From: Plant, Tom - Communities <Tom.Plant@Oxfordshire.gov.uk>
Sent: 25 October 2019 18:52
To: Shona King
Cc: DC Support; Cllr Arash Ali Fatemian
Subject: 19-02001-F - The Chaff Place Caravan High Street Bodicote OX15 4BS

Planning application:	19/02001/F
Location:	The Chaff Place Caravan High Street Bodicote OX15 4BS
Description:	Replace the boundary fence adjacent to the foot path
Type:	Full Development
Case Officer:	Shona King

Oxfordshire County Council, as the Local Highways Authority, hereby notify the District Planning Authority that they **object** to the granting of planning permission.

**SITE PLAN**  
(Scale 1:200)

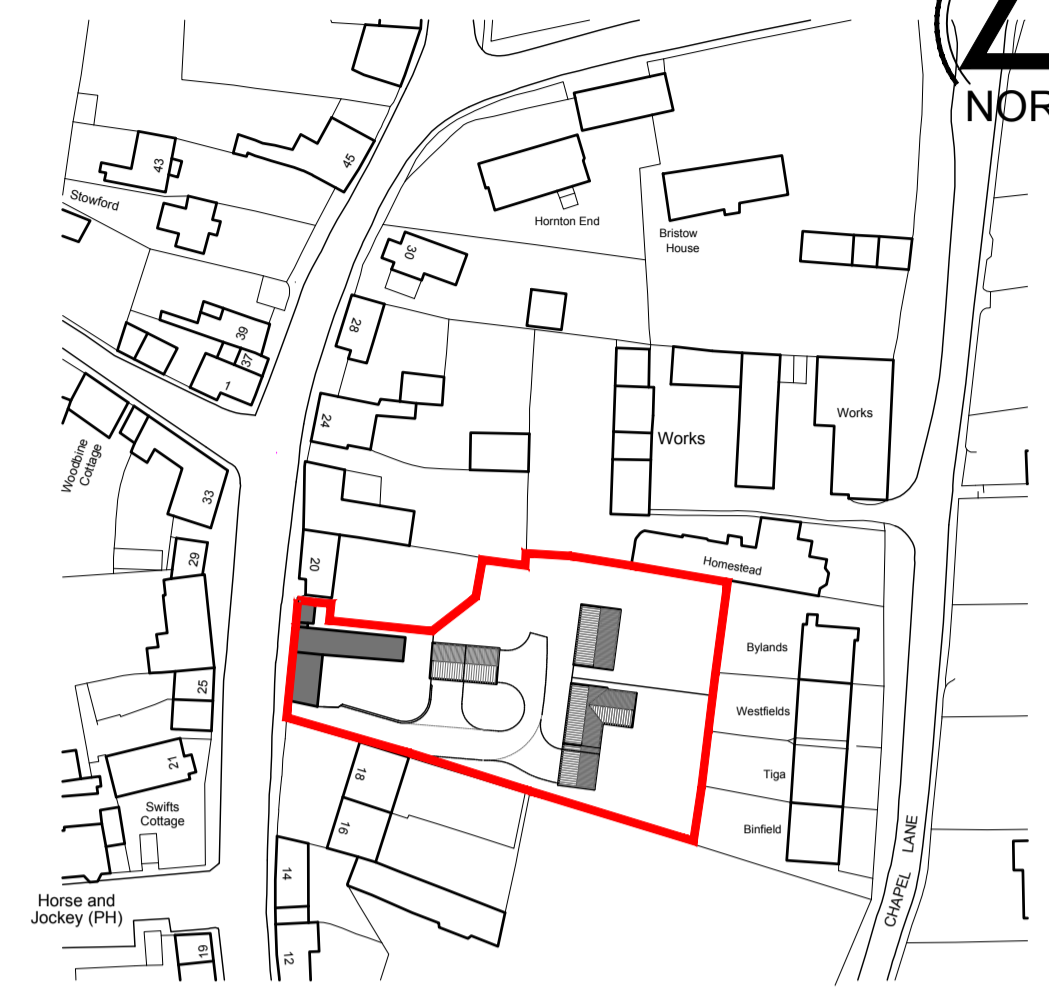
The proposed access visibility is obscured in both direction with the frontages of the adjacent dwellings fronting directly onto the footway. Therefore, in order to achieve suitable visibility, any vehicle egressing the site will have to push the nose of the vehicle out into the footway, which present not only a highway safety but a pedestrian safety hazard, thus one of the reasons for this objection.

The second reason for objection, is the insufficient width of the proposed access. I measured the width to be 3m's. The minimum acceptable width (that is without a passing space) is 4.8m's. I am aware of the previously approved scheme for the single dwelling which made use of this access (I commented on that application from the LHA). However, that was for one single dwelling. This proposal will lead to an intensification of this access with two thirds more trips than that of the previous consented scheme would potentially generate.
